REPORT UPDATE

Application No: EP/136/18/PL

LOCATION: Tudor Lodge
125A Sea Road
East Preston
BN16 1NX

PROPOSAL: Variation of condition 2 imposed under EP/59/17/PL relating to approved plans concerning updated site plan & ground floor plan.

Job No	Drawing No	Rev
6399	02	H

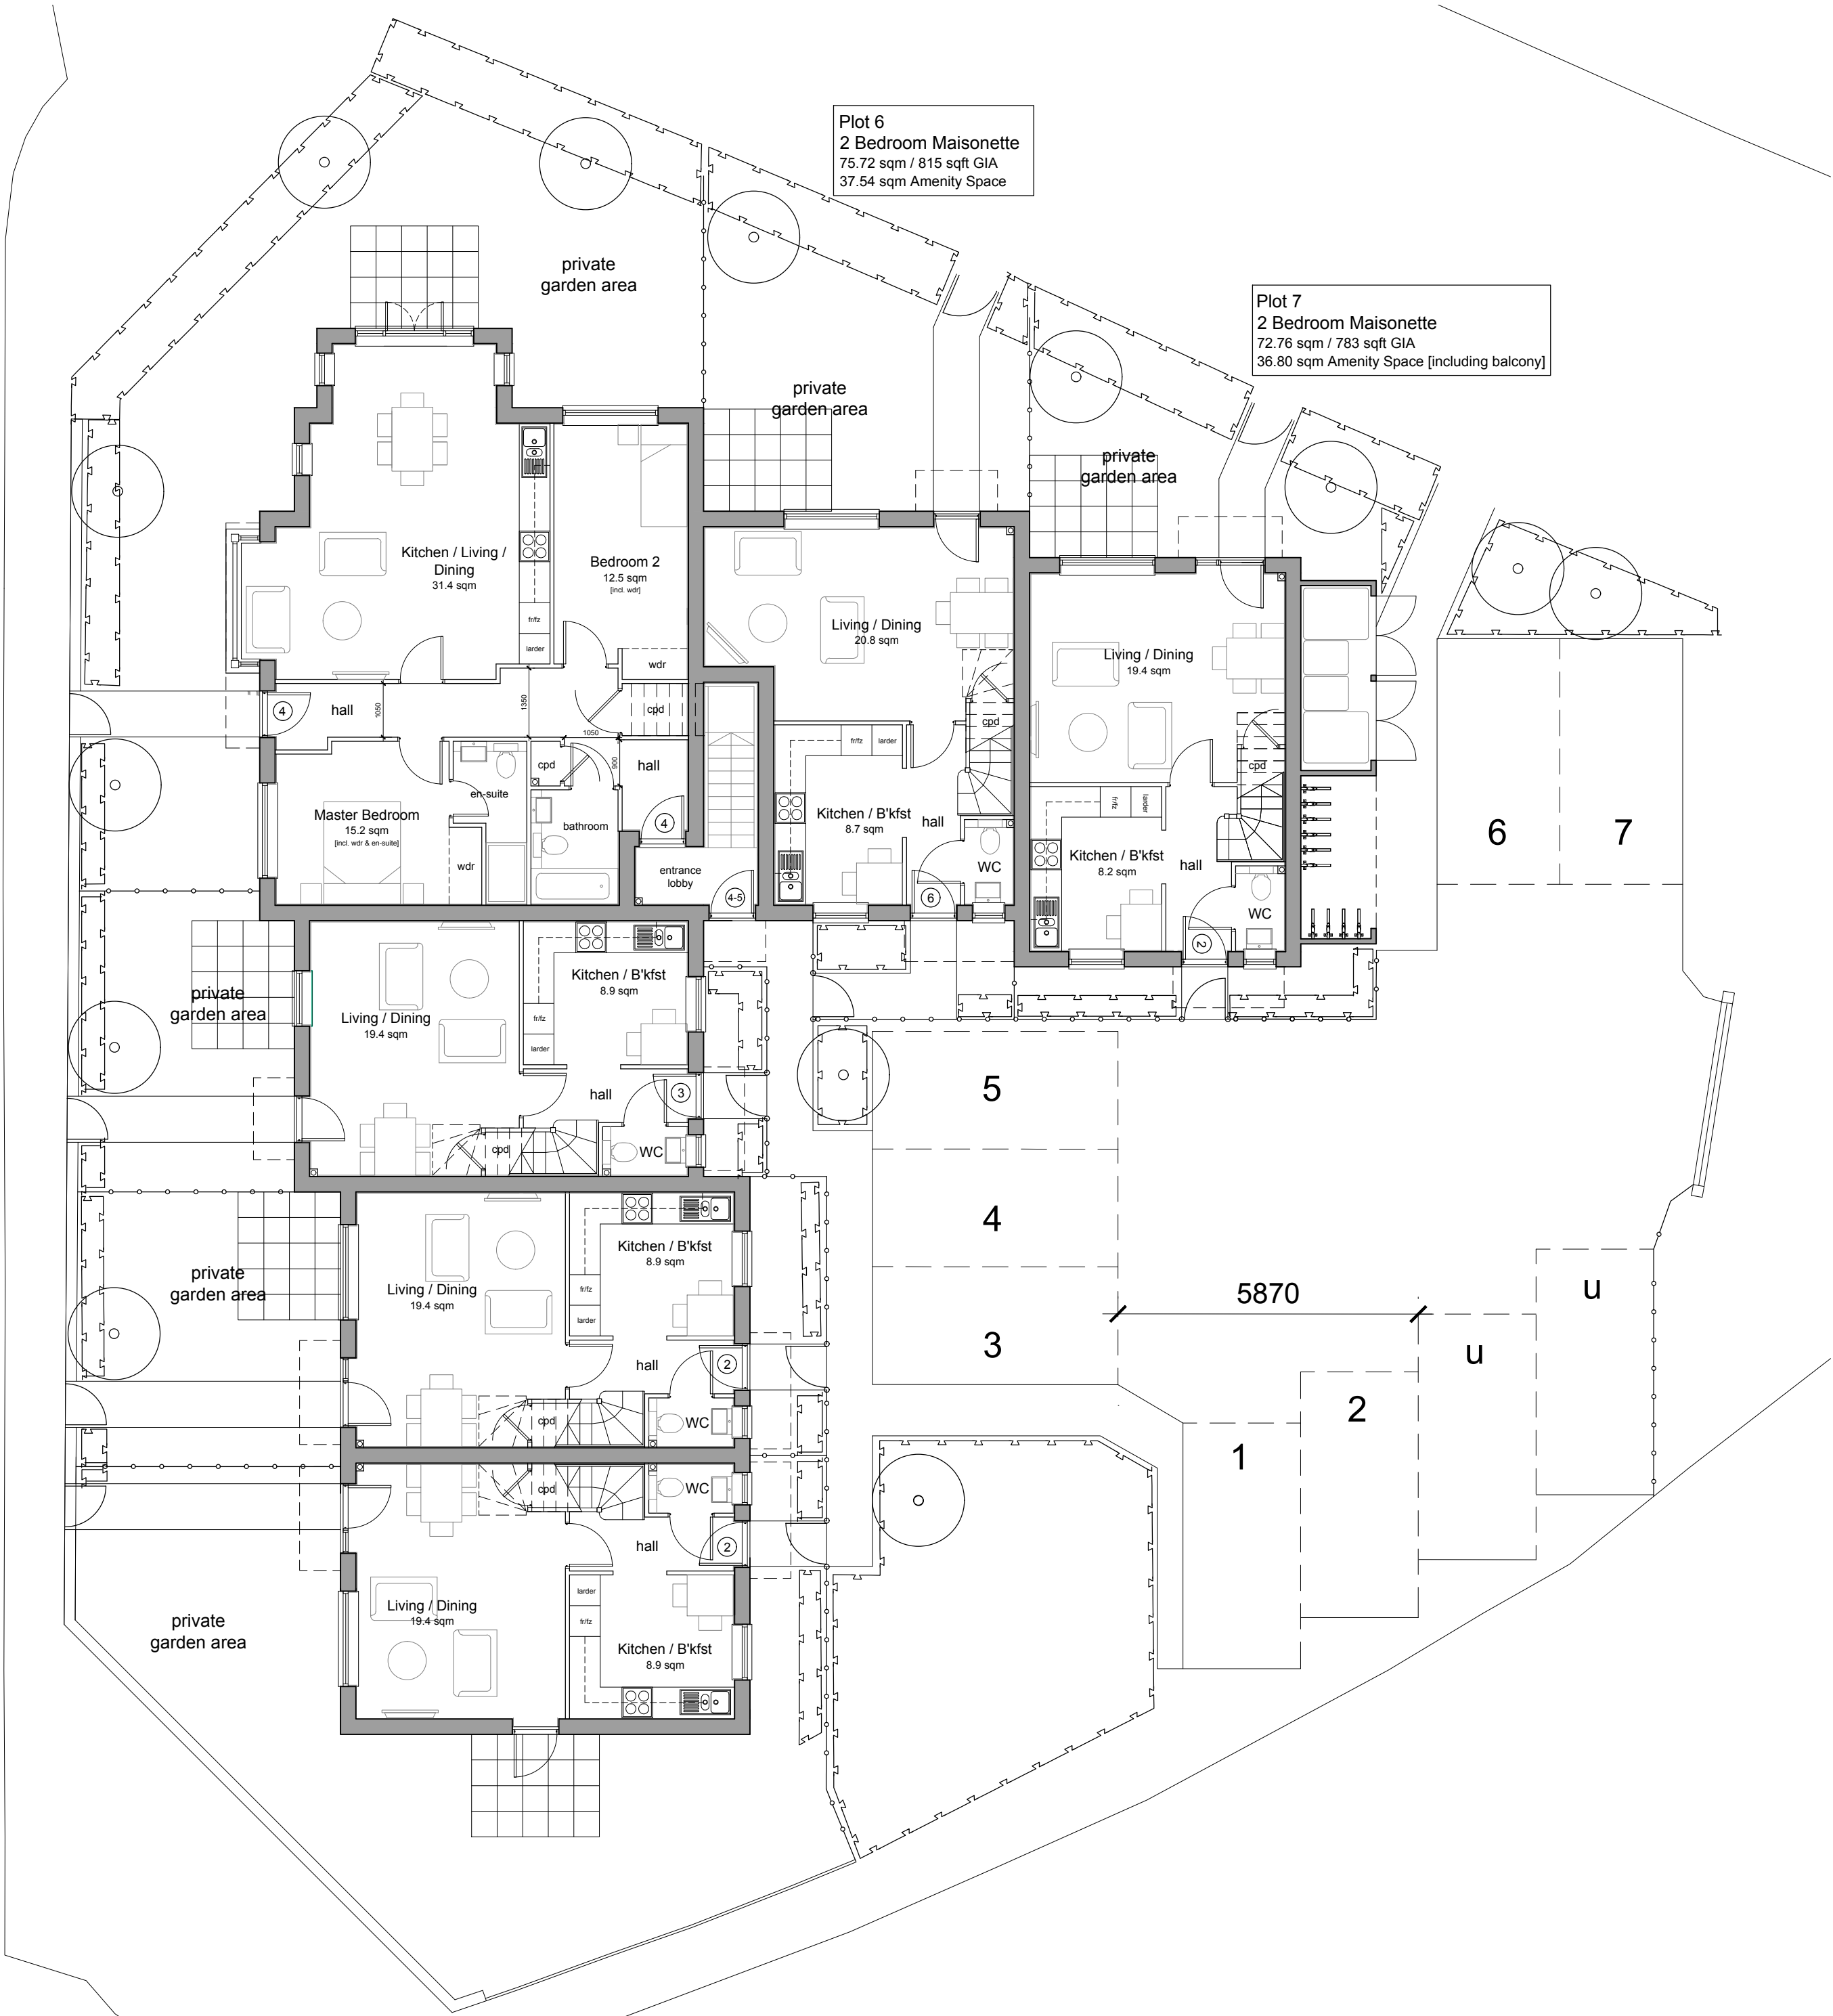
DESCRIPTION OF APPLICATION	The application seeks permission to alter the arrangement of parking spaces within the southern portion of the site, to facilitate a more efficient parking and landscaping arrangement, designed to improve drainage by the provision of a detention basin in this area.
	Tracking plans are submitted in support of the application and there is no change to the siting of the building, nor any other layout changes and the number of car parking spaces remains the same (9 in total).
SITE AREA	0.12 hectares.
RESIDENTIAL DEVELOPMENT DENSITY (NET)	58 dwellings per hectare.
TOPOGRAPHY	Predominantly flat.

There is no change to the site access, number of flats or number of parking spaces as previously approved. The only change to parking is a reconfiguration of the parking spaces.

The site plan has been amended since originally submitted to remove the reference to 8 flats which was incorrectly included in the legend on the drawing.

The site is located within the built-up area where the principle of development is acceptable and where an implemented planning permission EP/59/17/PL exists for 7 flats. The proposal only seeks permission for the revised parking layout to the approved development so as to facilitate a more efficient SUDS system, landscaping and parking arrangement.

The change to the parking layout would be a visual improvement to the layout of the site by reducing the extent of hard surfacing and providing a more meaningful area of landscaping which would assist in softening the appearance of the development. The proposal is therefore compliant with policy DDM1 (i) of Arun Local Plan and Policy 2: Design in Character Area One of the East Preston Neighbourhood Plan.

The proposed change to the parking layout would not materially alter the impact on neighbouring residential amenity. The position of the access remains unaltered and the number of spaces has not changed. However the revised parking layout increases the area of landscaping in the south west corner of the parking area which would result in an improved outlook for some of the Palm Court Cottages and would improve the residential amenity of occupiers of the most southerly units in the development.
